Re: J1024-5798  
Lot 10 Heritage @ Neills Creek

Pages or sheets covered by this seal: I71852799 thru I71852800

Job	Truss	Truss Type	Qty	Ply	Lot 10 Heritage @ Neills Creek	I71852799
J1024-5798	A18	MONOPITCH	6	1	Job Reference (optional)

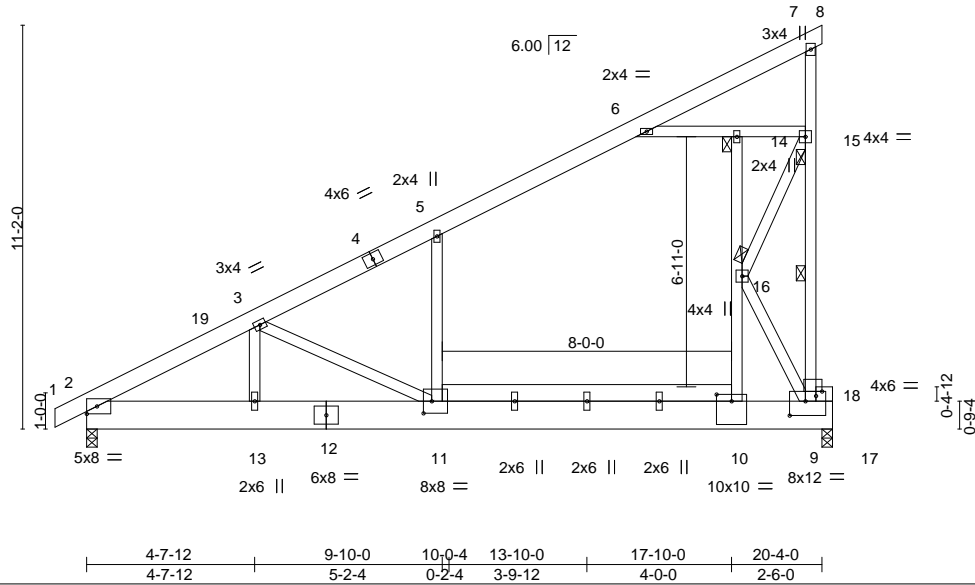
SAME REPAIR AS A18. (I71852799)

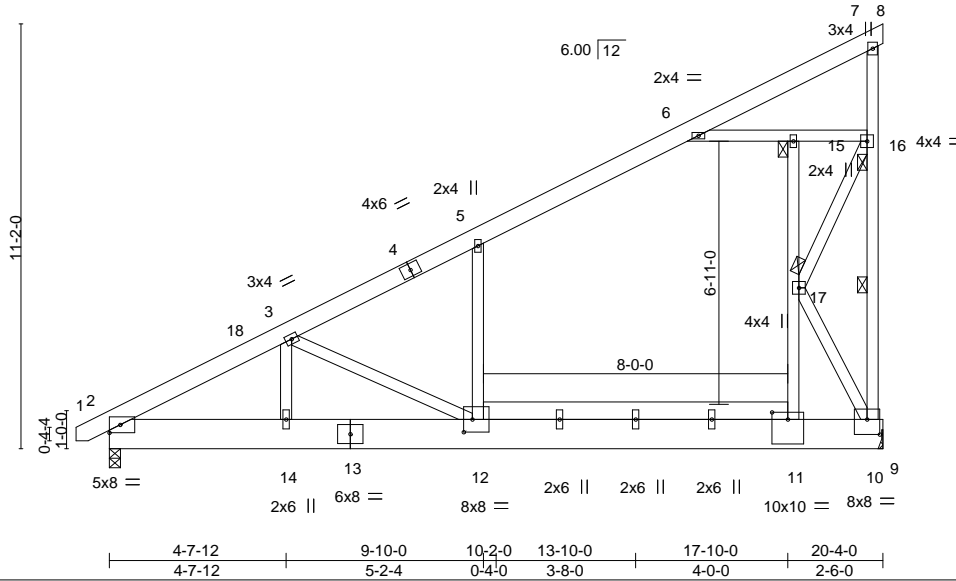
REPAIR: ADD EXTRA LOADING TO TOP CHORD AS REPORTED

ATTACH 1/2" PLYWOOD OR OSB GUSSET (15/32" RATED SHEATHING 32/16 EXP 1)  
TO EACH FACE OF TRUSS WITH (0.131" X 2.5" MIN.) NAILS PER THE FOLLOWING NAIL SCHEDULE:  
2 X 3'S - 2 ROWS, 2 X 4'S - 3 ROWS, 2 X 6'S AND LARGER - 4 ROWS: SPACED @ 4" O.C.  
NAILS TO BE DRIVEN FROM BOTH FACES. STAGGER SPACING FROM FRONT TO BACK FACE  
FOR A NET 2" O.C. SPACING IN EACH COVERED TRUSS MEMBER. USE 2" MEMBER END DISTANCE.
